**WELWYN HATFIELD BOROUGH COUNCIL
EXECUTIVE DIRECTOR - PLANNING, PUBLIC PROTECTION AND GOVERNANCE**

DELEGATED APPLICATION

Application No: 6/2018/1564/HOUSE
Location: 12 Daisy Drive Hatfield AL10 9FR
Proposal: Conversion of garage to habitable space including alterations to openings
Officer: Mr Richard Sakyi

Recommendation: Granted

[03] SITE PLAN 1:200

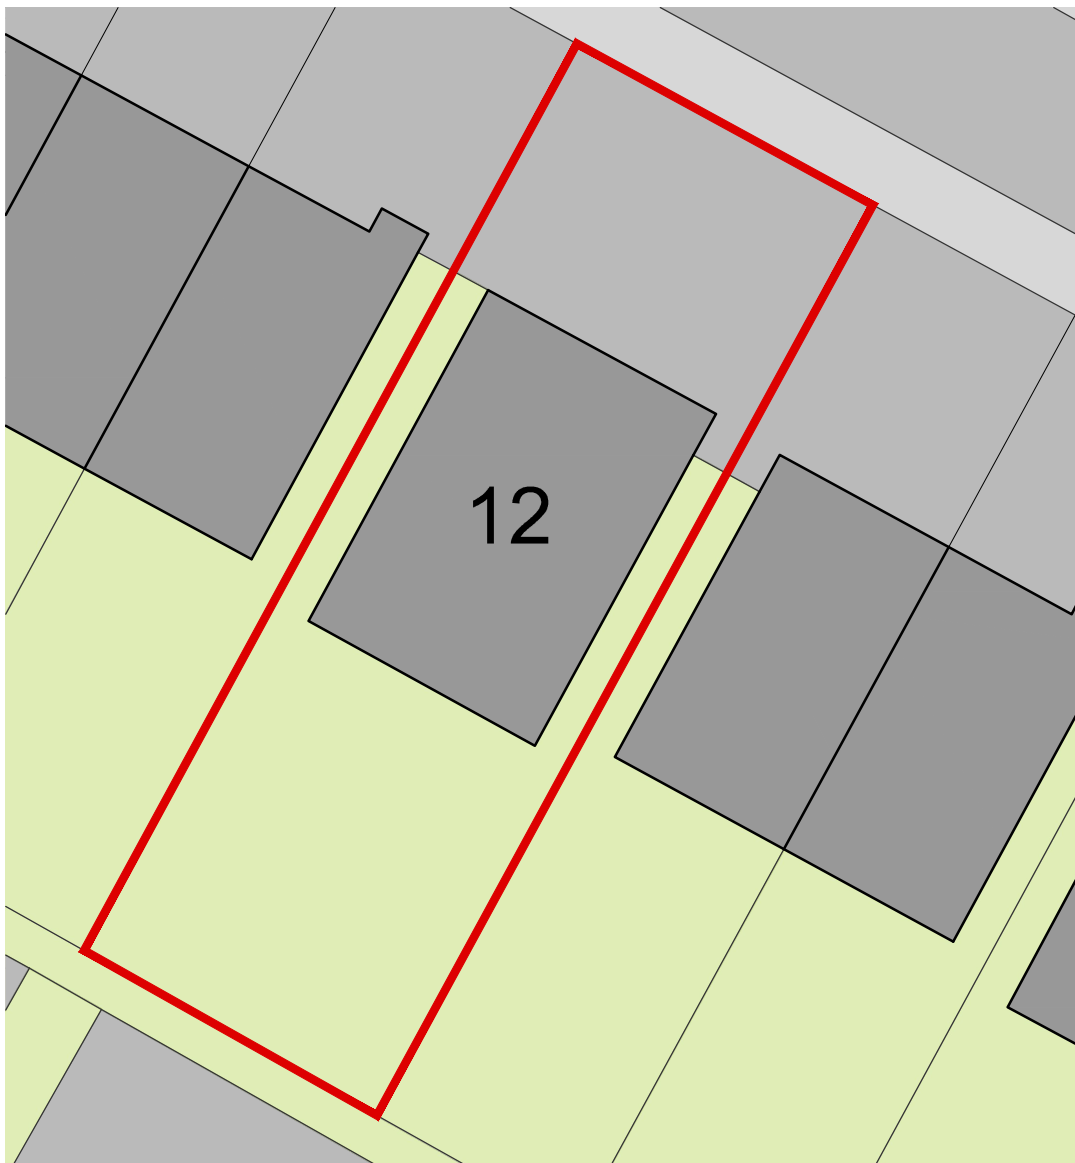
| | <p>of hard surfacing and parked vehicles.</p> <p>In this case, the proposed additional parking space would result in an increase in the amount of hardstanding to the frontage of the site to provide parking in accordance with the Council's adopted Parking Standards. Increased levels of hardstanding to accommodate car parking can degrade the quality, character and appearance of an area. Also, no details have been provided in terms of how surface water would drain from the extended parking area. To reduce surface water run-off the parking area should be laid with a permeable surface, or alternatively drain to a soft landscaped area.</p> <p>No landscaping details have been provided, therefore, it would be reasonable to attach a planning condition requiring a detailed landscaping scheme to be submitted and approved by the Local Planning Authority in order to reduce the visual and environmental impacts of the development. A landscaping scheme would include:</p> <ul style="list-style-type: none"> • hard surfacing and other hard landscape features and materials; • planting plans including specifications of species, sizes, planting centres, number and percentage mix, and details of seeding or turfing. |

1. The area set aside for car parking shall be laid out and surfaced in accordance with a scheme which has been submitted to and agreed in writing by the Local Planning Authority before the extension/alterations hereby permitted is first brought into use and shall be retained permanently thereafter for the free parking of vehicles for residents/occupiers of the development permitted and shall not be used for any other purpose.

2. No development shall take place until full details on a suitably scaled plan of both hard and soft landscape works have been submitted to and approved in writing by the Local Planning Authority. The development shall not be carried out other than in accordance with the approved details.

**PROPOSED PLANS + ELEVATIONS**

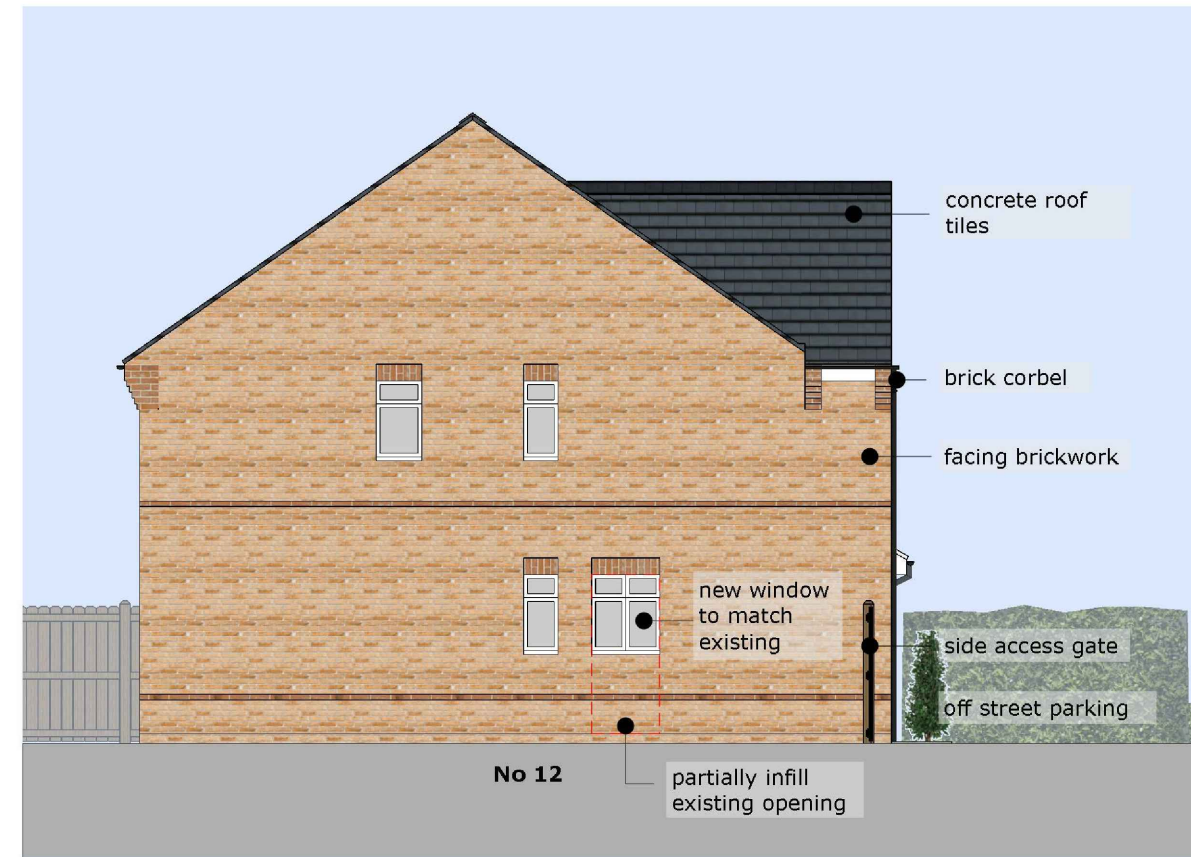
| Design (form, size, scale, siting) and Character (appearance within the streetscene) | The proposed alteration works which would to enable the conversion of the garage into a playroom are considered acceptable with regard to the external materials, size and siting of the window and impact on the character and appearance of the building and the general streetscene. |
| Access, car parking and highway considerations | <p>The dwellinghouse, as originally designed, has a provision of three car parking spaces - one single space within the garage and two parking spaces on the hardstanding in front of the garage which is an integral part of the design of this development.</p> <p>The current proposal would retain the amount of parking spaces (3 no.) within the forecourt area of this four bedroom dwelling. This include the addition of one space and as such considered acceptable as the loss of the use of the existing garage would be offset by the provision of the additional parking space within the site. It is recommended that a condition be imposed to ensure that the additional car parking space is laid out as depicted on the submitted plan to ensure adequate parking provision remain within the site at all times.</p> <p>The proposal is therefore acceptable and complies with the NPPF and Policies D1, D2 and M14 of the Welwyn Hatfield District Plan 2005.</p> |
